RE: Responses to Comments on the Traffic Impact Study for the Haven School

El Paso County provided comments on the traffic impact study for this project that was dated August 25, 2023. Sustainable Traffic Solutions has responded to the comments as noted below.

## Comments received from El Paso County on October 15, 2023

# Haven School

Haven School Traffic Impact Study
CONCEPTUAL IMPROVEMENT SKETCH FOR THE SITE ACCESS ON BURGESS ROAD

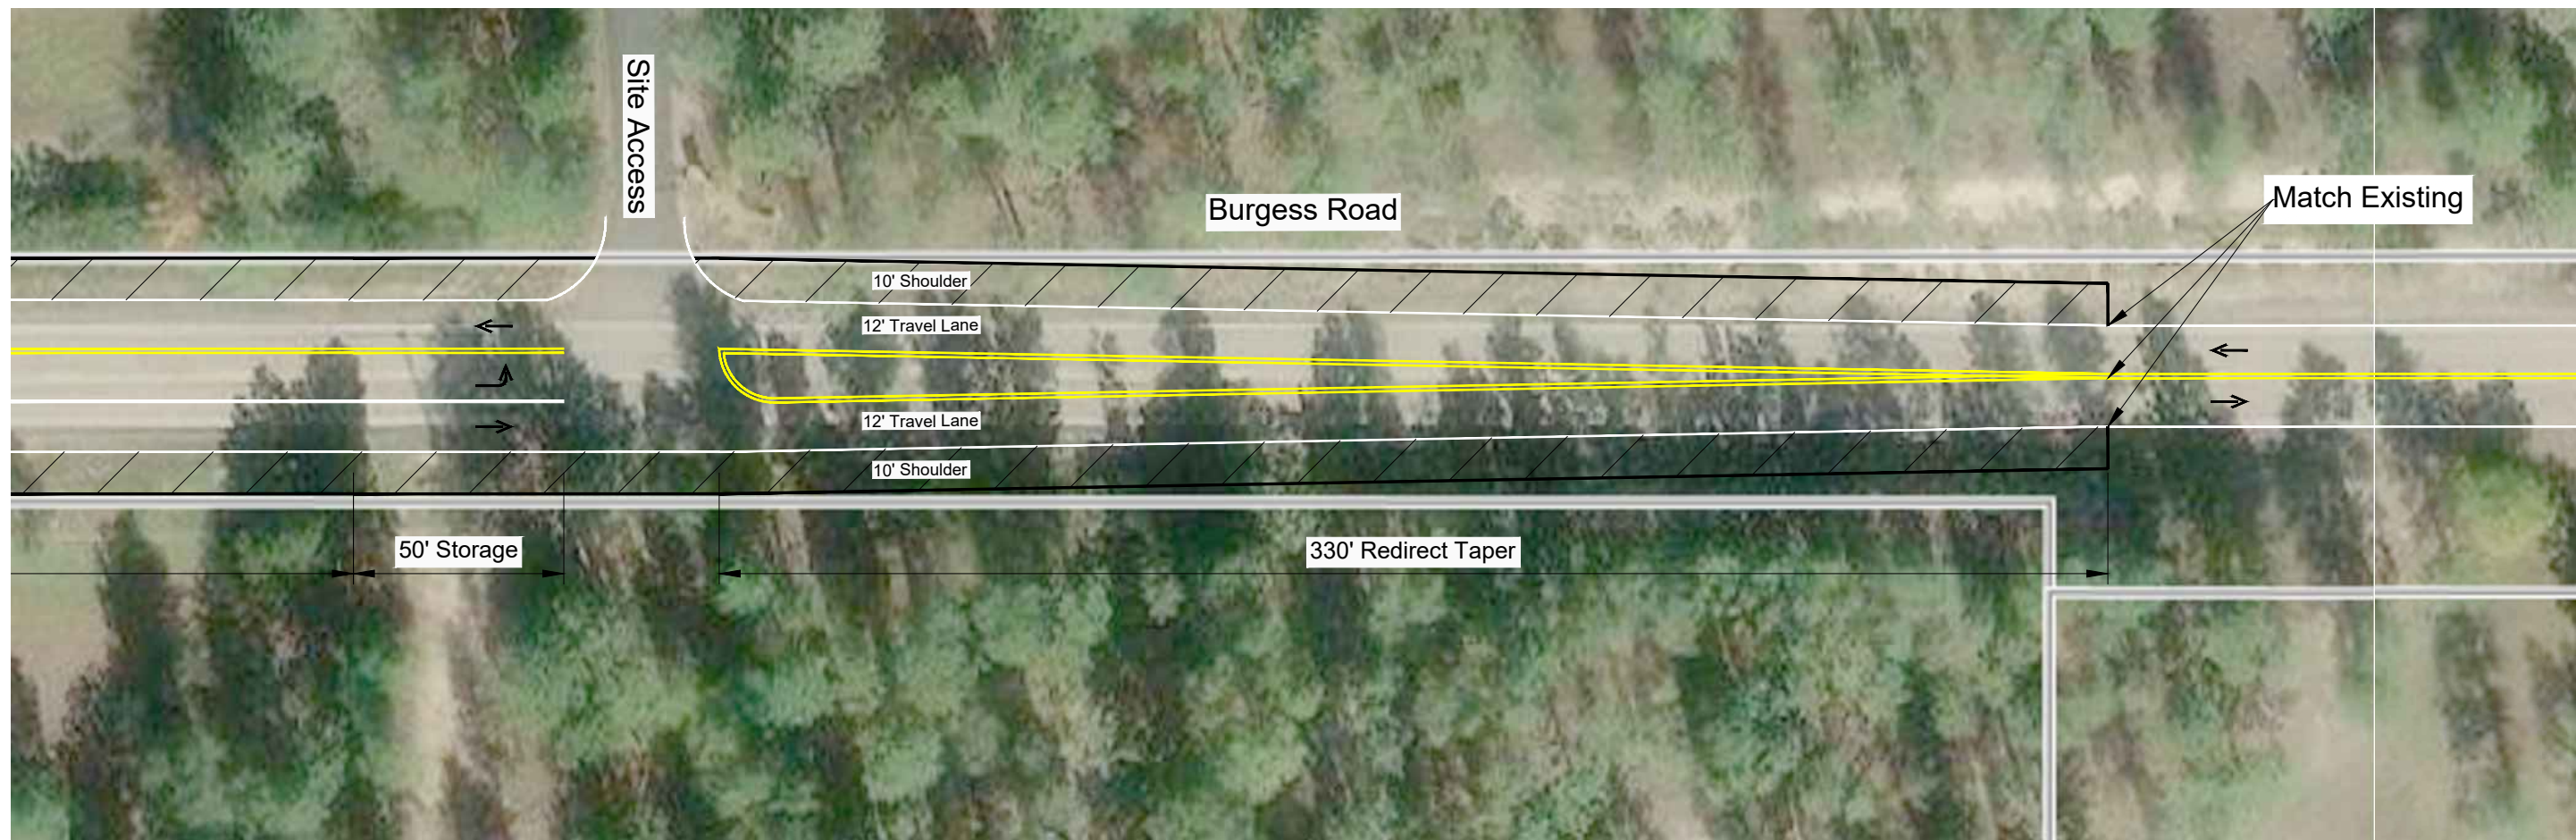
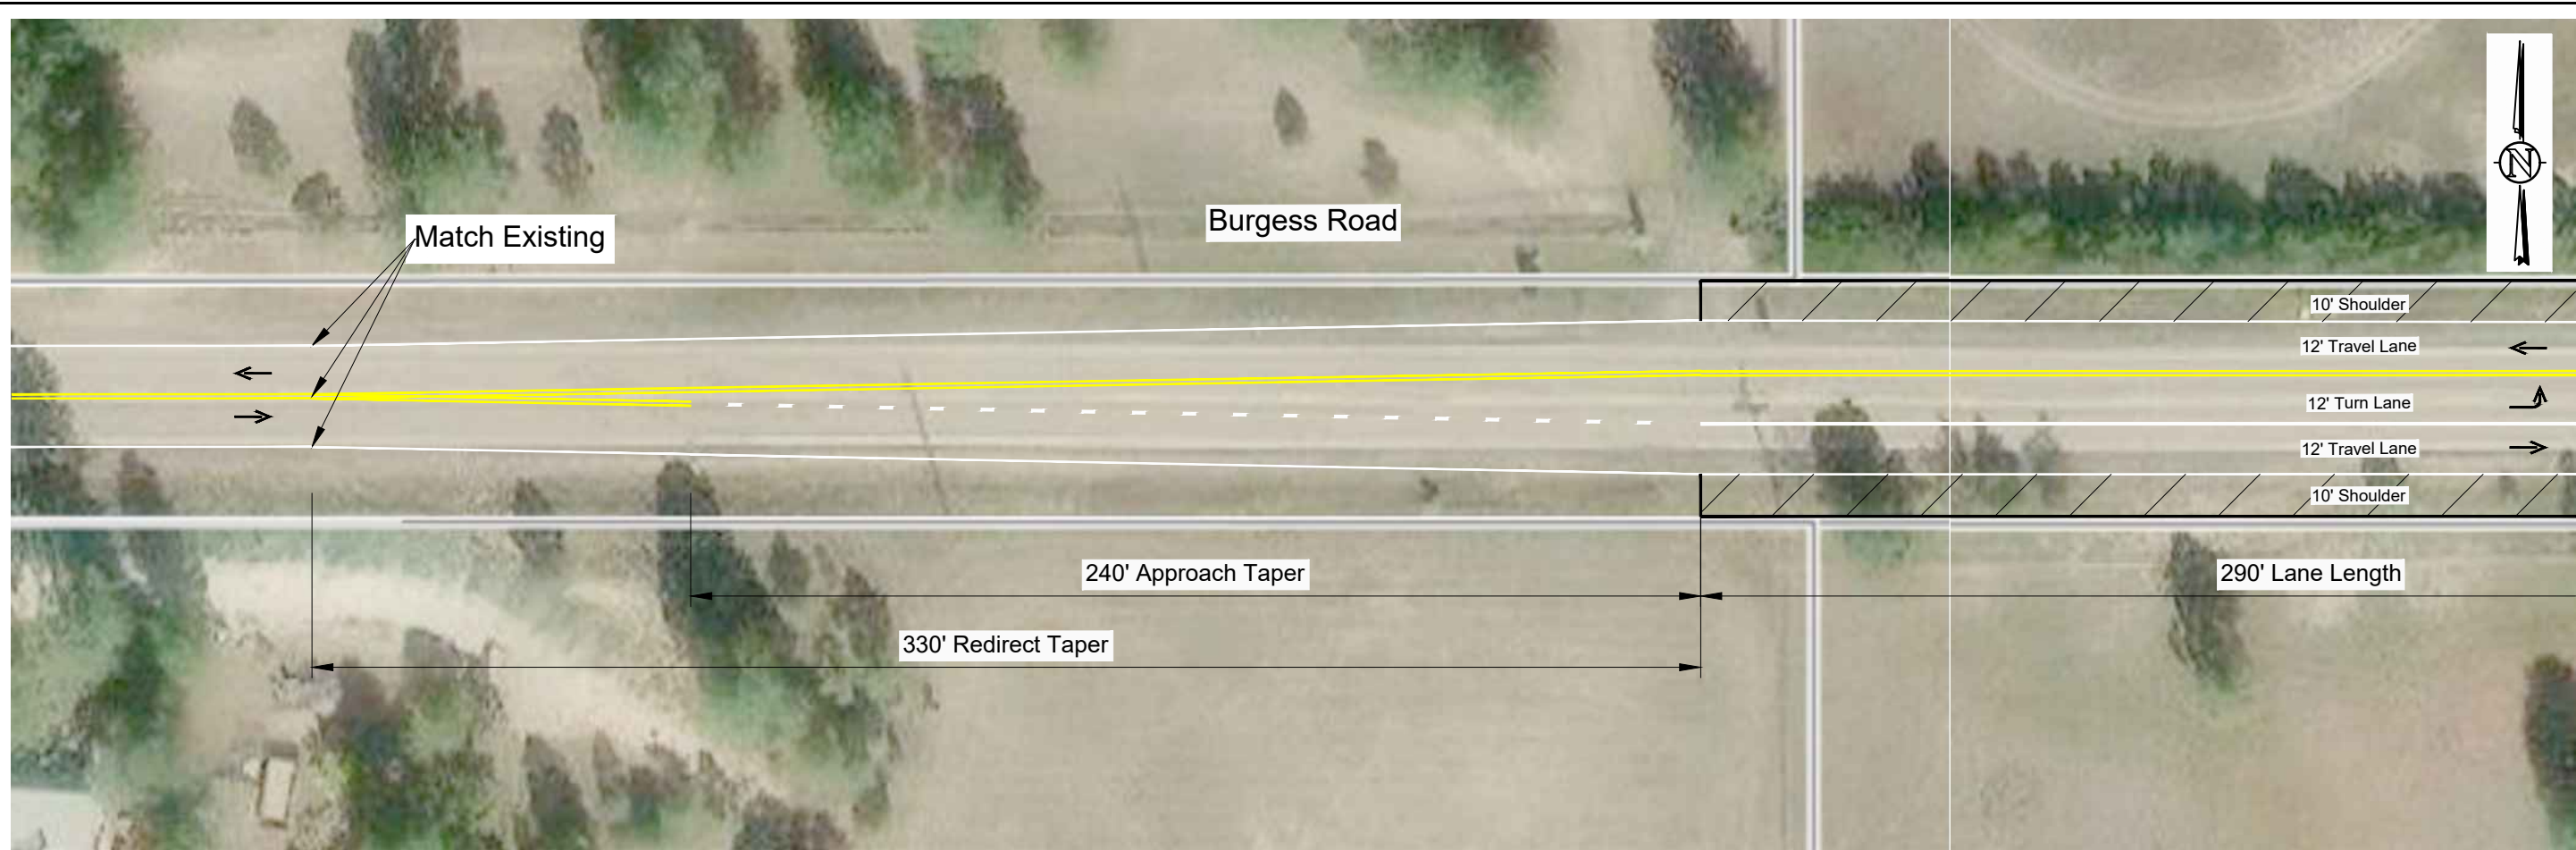
**Comment 12** Please state in the text whether or not a right turn decel lane or acceleration lane is required at the access. Additionally, please analyze and state whether any turn lanes are required or need to be modified at Burgess/Milam and Burgess/Black Forest due to this development's traffic impacts.

**Comment 22** From GIS aerials there is no existing aux. left turn lane at the access. Revise accordingly.

**Response** Table 4 was updated to include a review of the auxiliary lanes at Burgess Road / Milam Road. It wasn't necessary to review the need for auxiliary lanes at

CONCEPTUAL IMPROVEMENT SKETCH FOR MILAM ROAD AT BURGESS ROAD

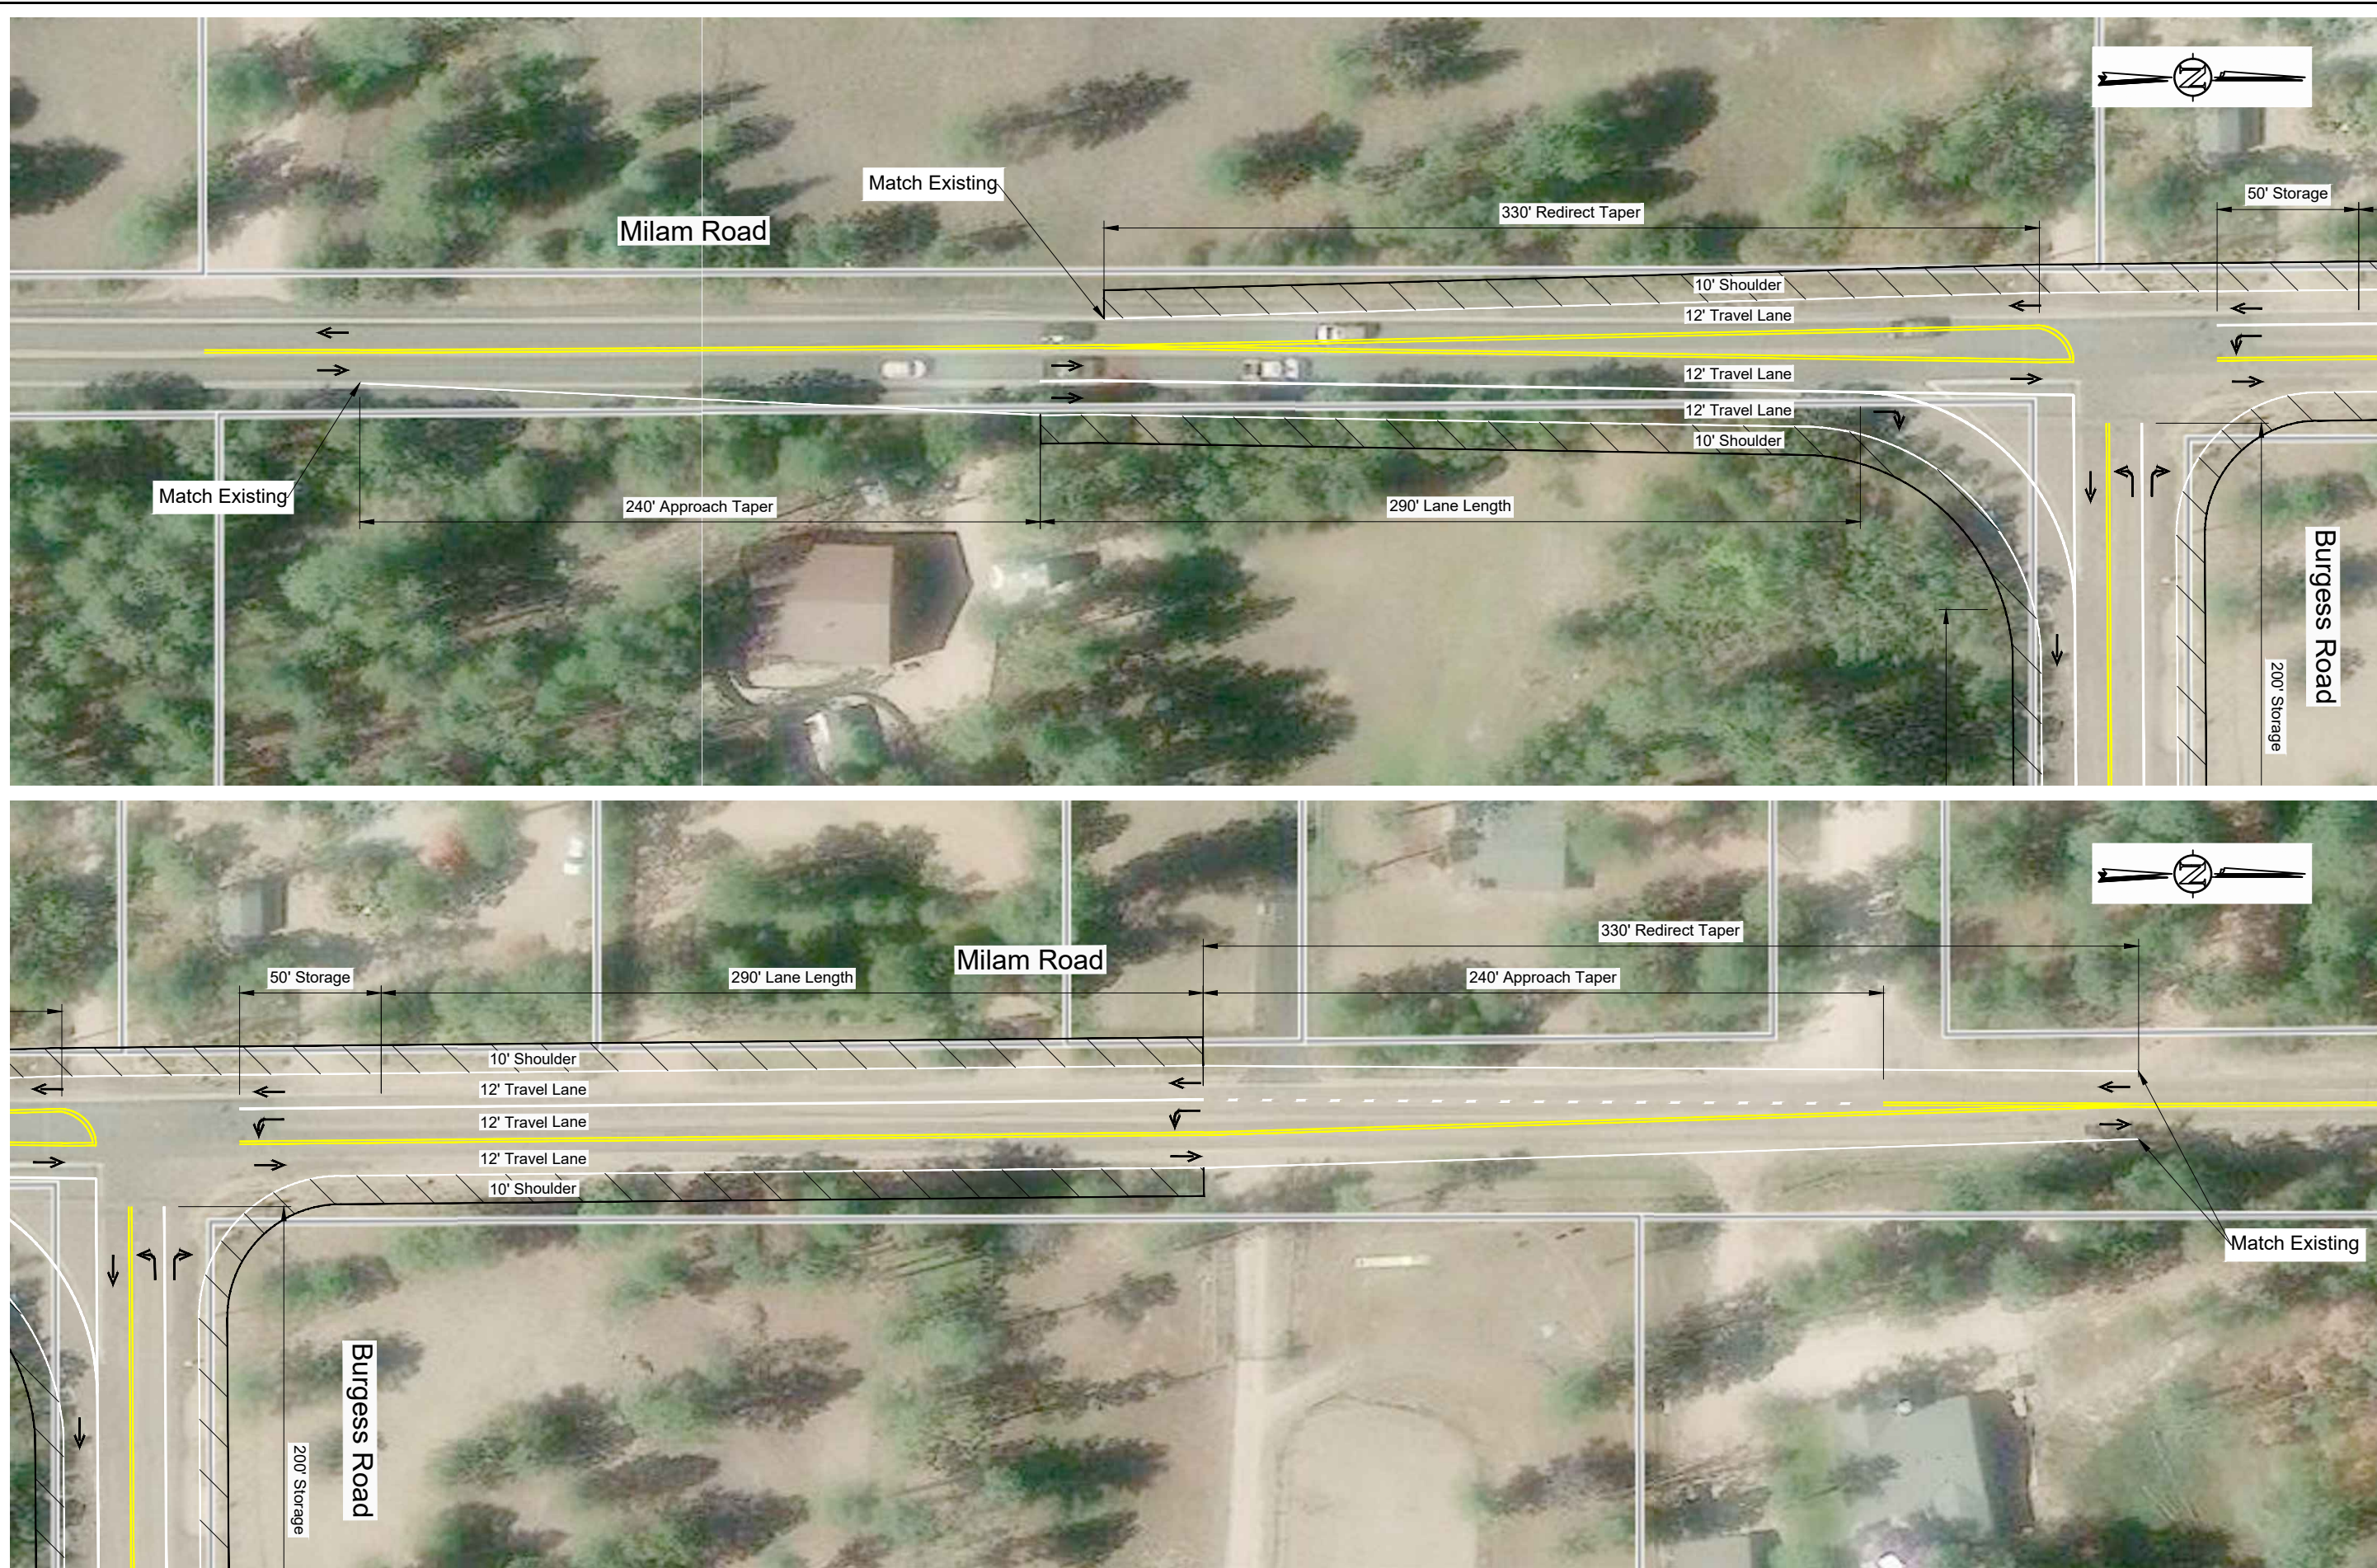
**Comment 24** The addition of a southbound Milam left turn to Burgess will need to be included for an escrow cost share based on the added traffic.

**Comment 25** The TIS will need to include the turn lane lengths, widths, and taper.

**Response** The estimated for the cost for the improvement is discussed in Section 9.1.

**Response** Refer to Tables 4 and 5.

Haven School Traffic Impact Study
CONCEPTUAL IMPROVEMENT SKETCH FOR BURGESS ROAD AT MILAM ROAD

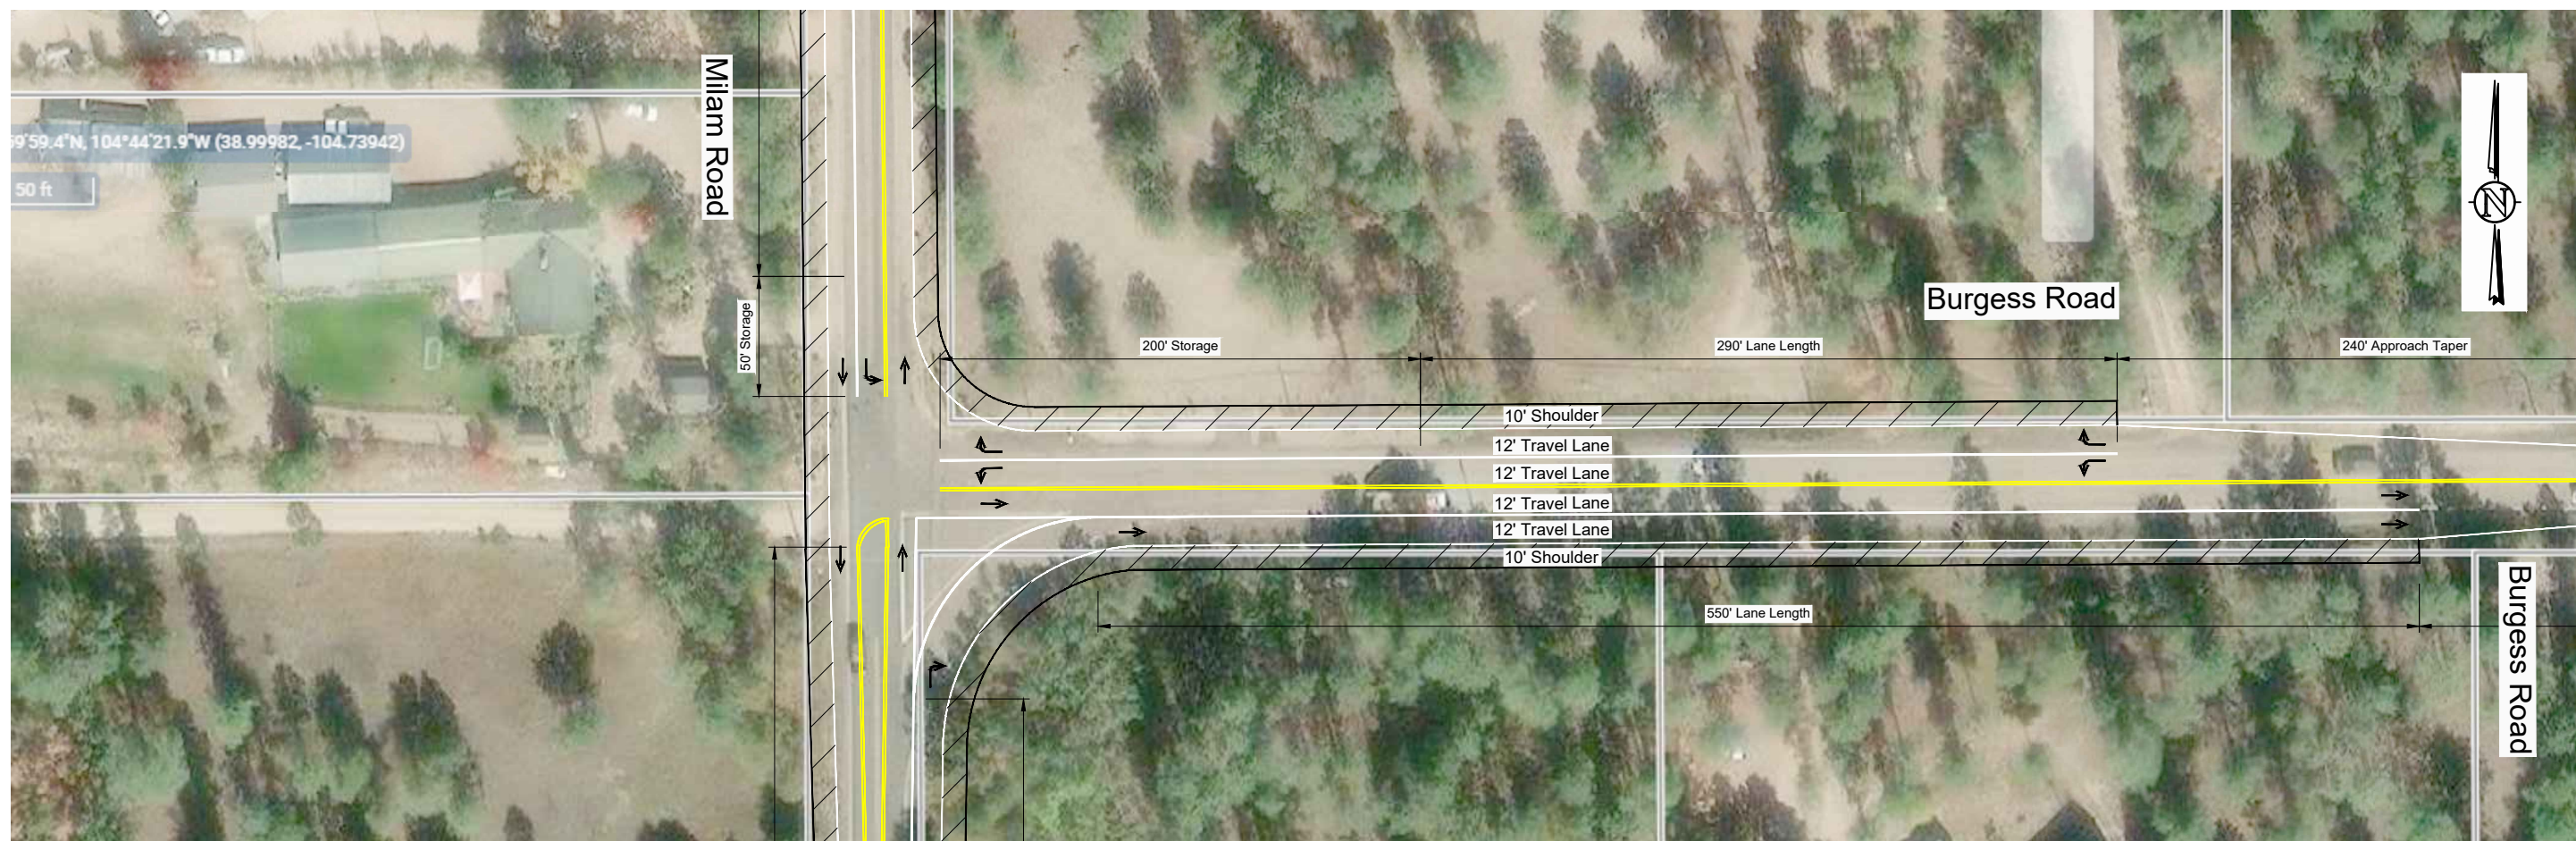
**Comment 27** The westbound Burgess at Milam will need to be included for escrow cost share for right and left turn lanes based on added traffic.

**Comment 28** The TIS will need to include the turn lane lengths, widths, and taper for these two turn lanes.

**Response** The estimated for the cost for the improvement is discussed in Section 9.1.

**Response** Refer to Tables 4 and 5.
